From: [REDACTED]
To: [West Burton Solar Project](#)
Cc: [REDACTED]
Subject: FW: EN010132 – West Burton Solar Farm
Date: 09 January 2024 19:22:00

With respect to the Examining Authority's written questions and requests for information, Nottinghamshire County Council has the following responses to make. For speed, these comments are made in the form of an email rather than a formal letter.

Application by West Burton Solar Limited for an Order Granting Development Consent for the West Burton Solar Project

**Land Plans**  
Sheet 1 of 10  
Revision C

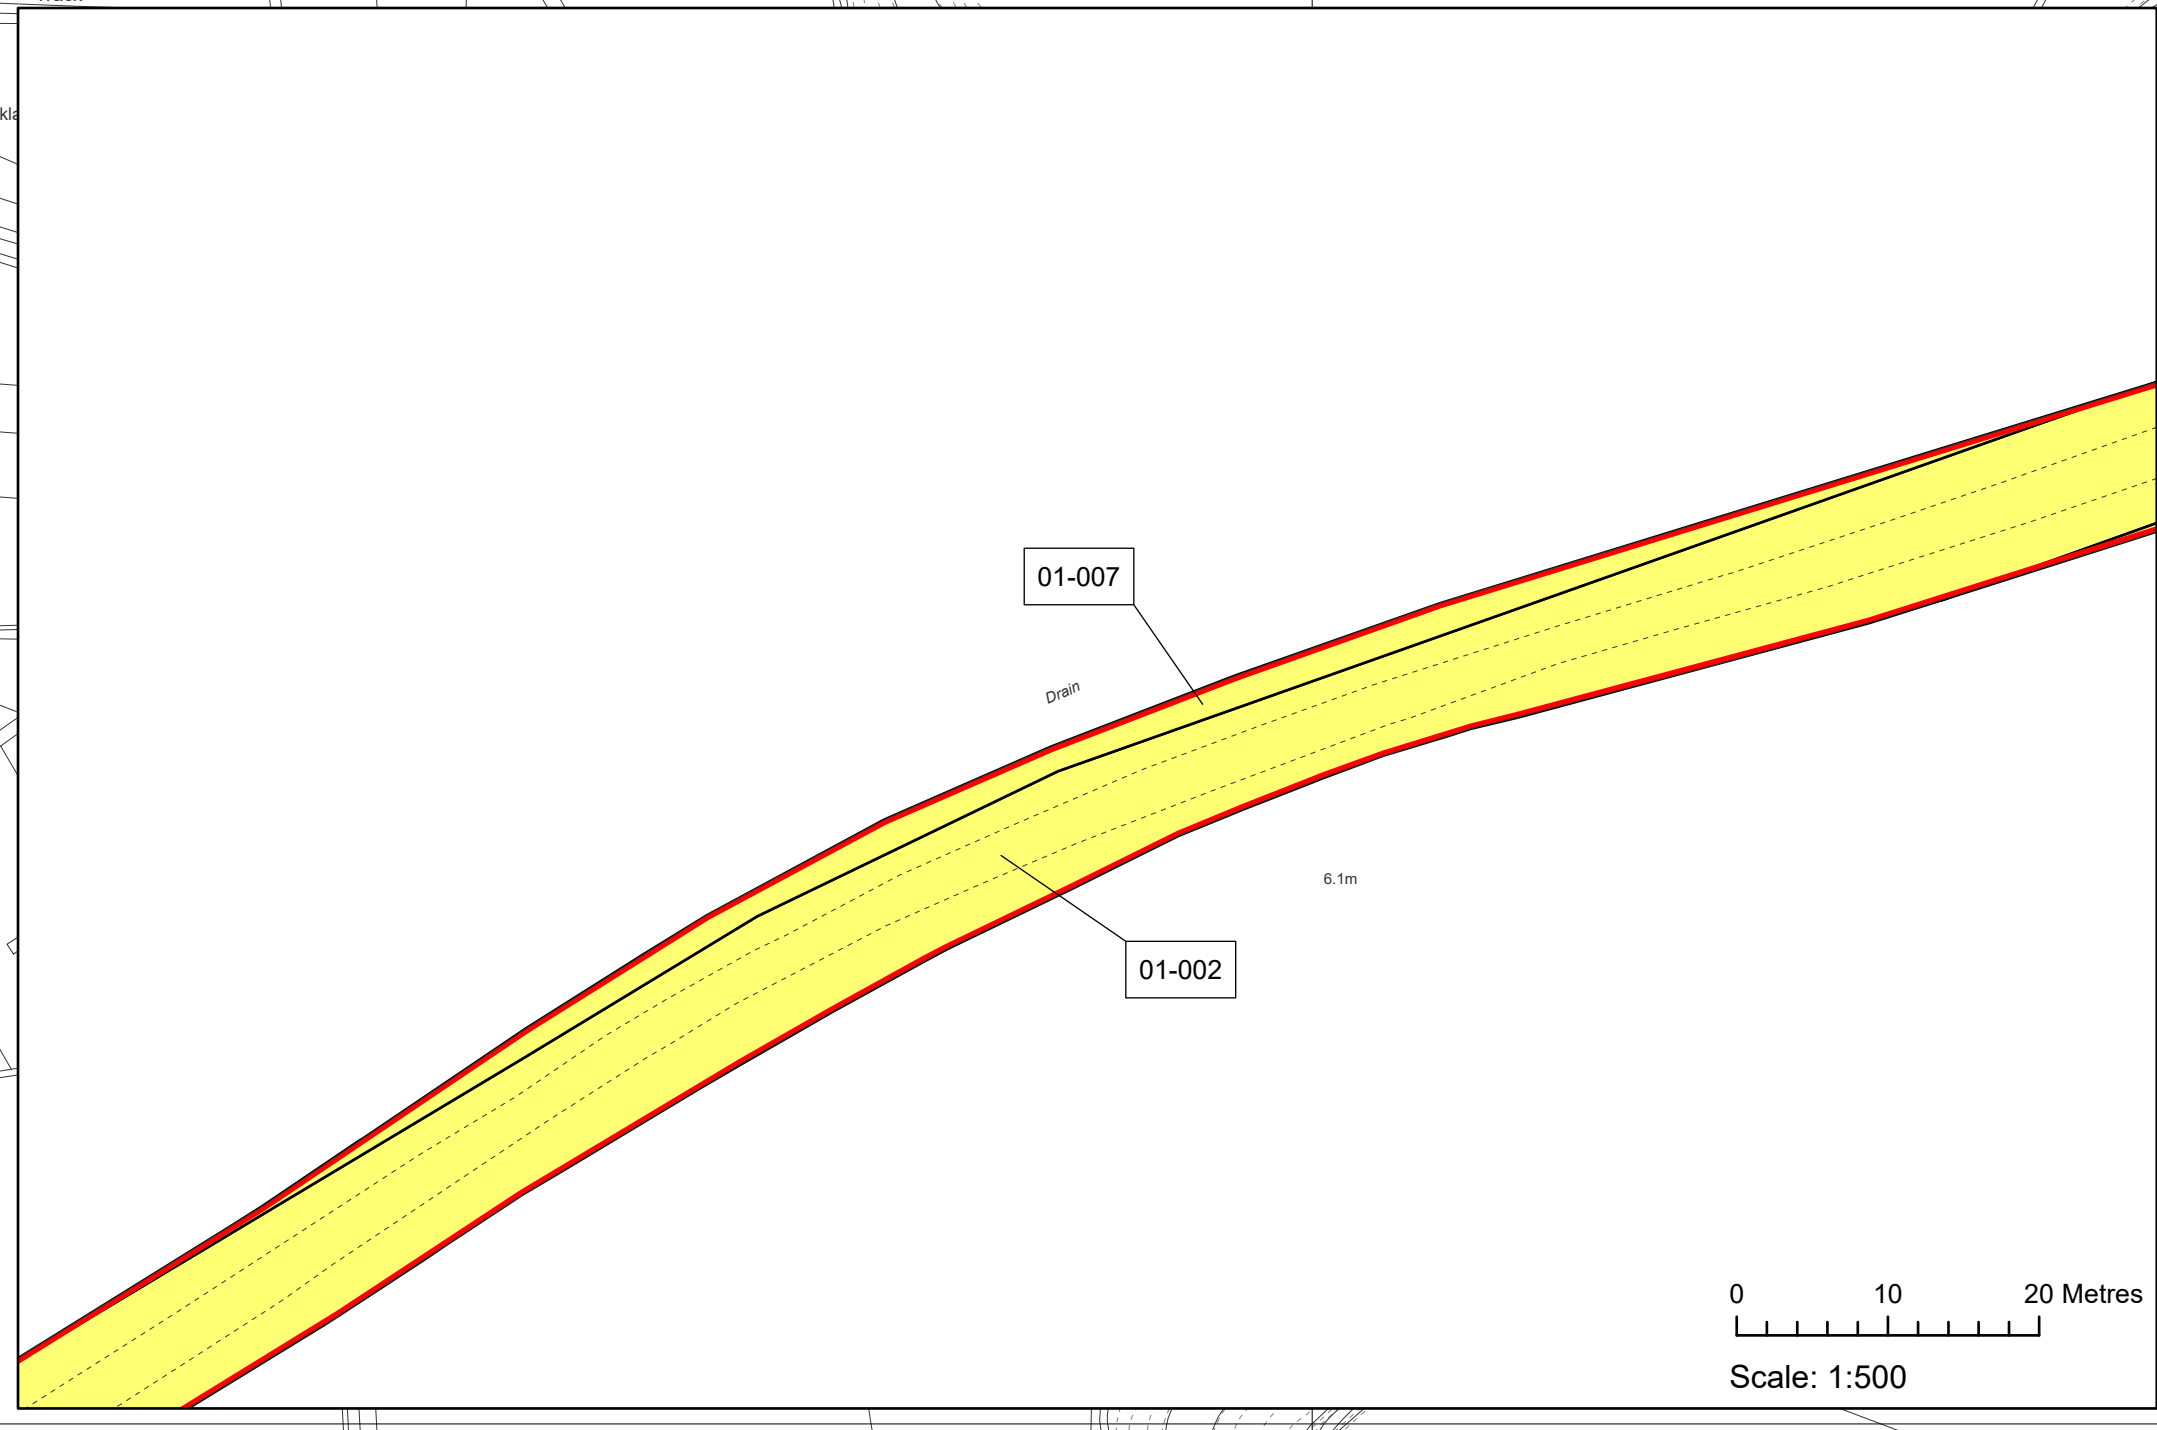
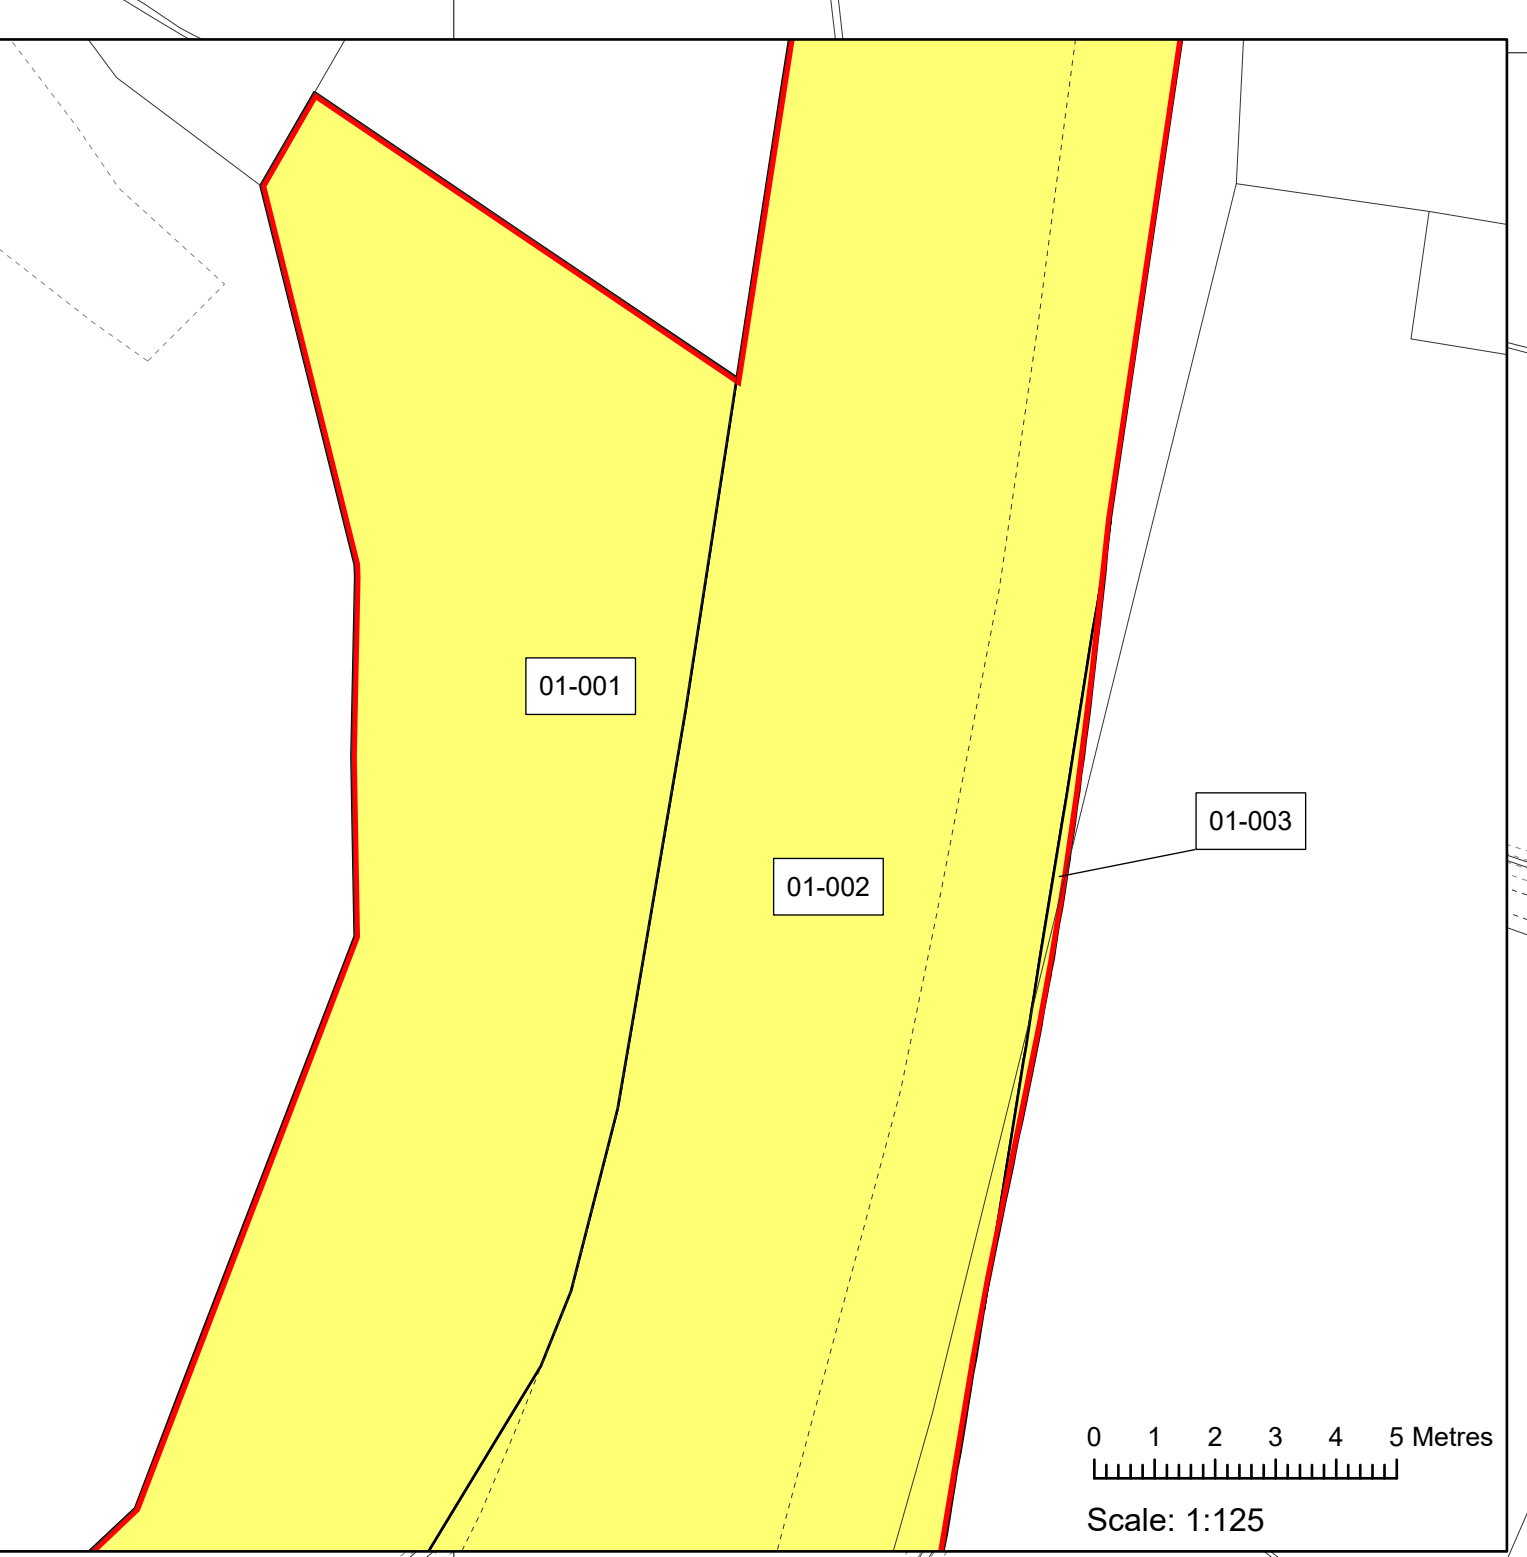
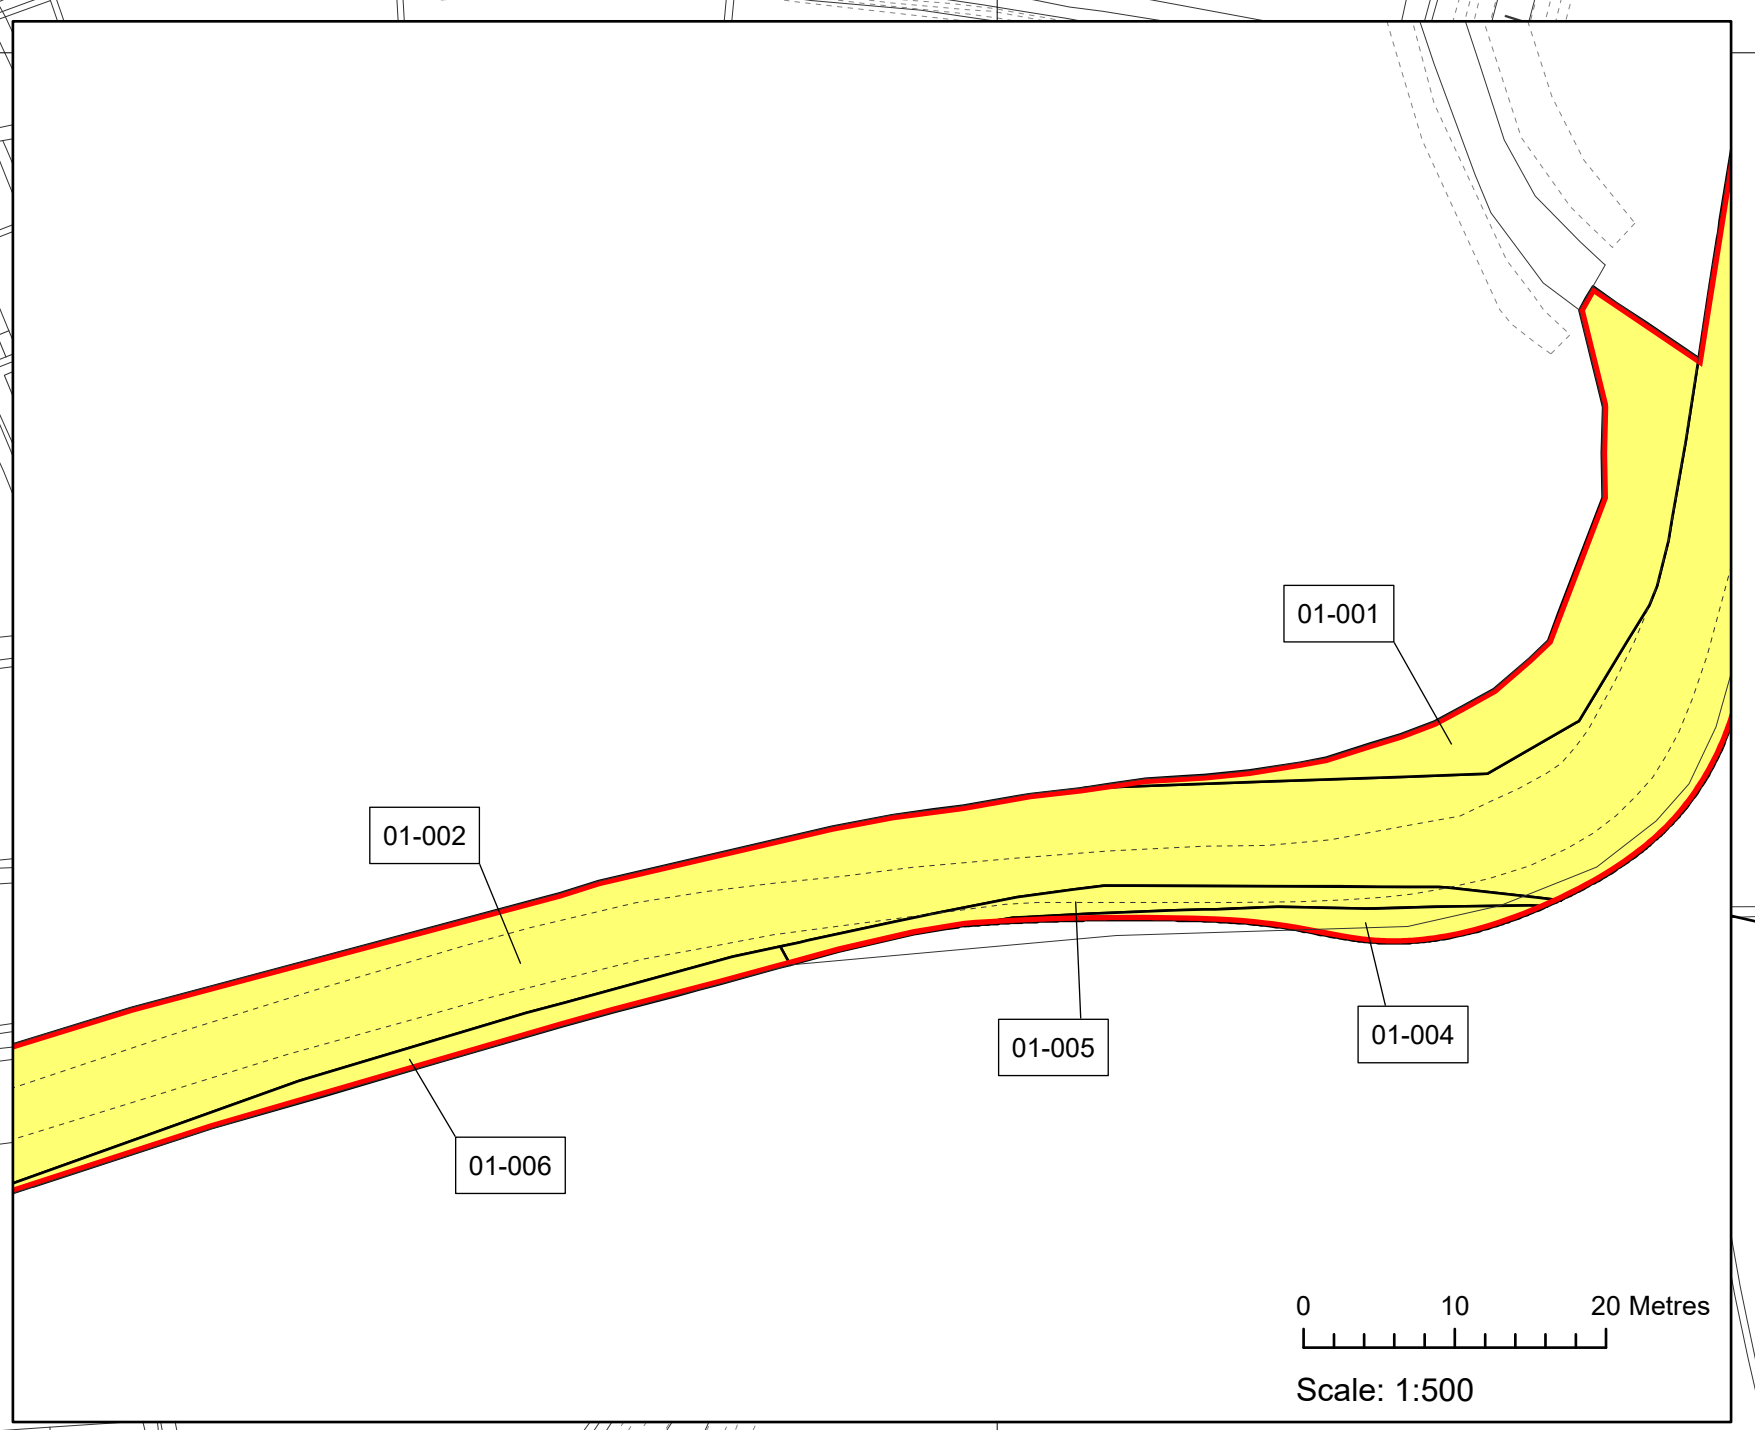
In terms of compulsory acquisition (shaded blue on the Land Plan), this primarily relates to land associated with the cable corridor. Whilst this route does cross the public highway it will have no effect on its legal status as Highway. All public highway is subject to the legal maxim, 'once a highway always a highway' which applies regardless of any change in ownership, unless a separate stopping up order is granted by the Secretary of State for Transport. Regardless of ownership the provisions of the Highways Act 1980, Traffic Management Act 2004, and associated legislation such as the New Roads and Street Works Act 2004, will still apply. Any works contained within the Highway would be subject to legal provisions, agreements and licences required under the associated legislation.

These provisions regulate construction works within the highway as well as other associated activities such as the laying of services and cables etc. Consequently, it is unclear why any change of ownership or compulsory acquisition of land within the Highway Boundary would be required.

The same applies to land for which temporary possession is being sought (shaded yellow on the land plan). Any temporary works within the Highway required for access etc, would be covered by the relevant legislation. There may be an argument that temporary possession of land outside of the Highway may be required to facilitate access for larger vehicles and abnormal loads. However, having reviewed the Abnormal Load strategy contained within Appendix F of the Transport Assessment, for the access points located in within Nottinghamshire (access points AC103 – AC108), it would appear only access point AC108 is likely to require third party land, presumably to allow vehicles to turn around at the end of the route.

There are a number of smaller areas of land shown as temporary possession direct adjacent to access points located at AC103, AC104, and AC107. These do not appear to be required for access purposes, it is presumed given their proximity to the Highway that they are being acquired by the developer on a temporary basis for use as site compounds / staging areas. We are unable to comment as to whether or not these areas are excessive as the area required will be subject to operation requirements determined by the developer.
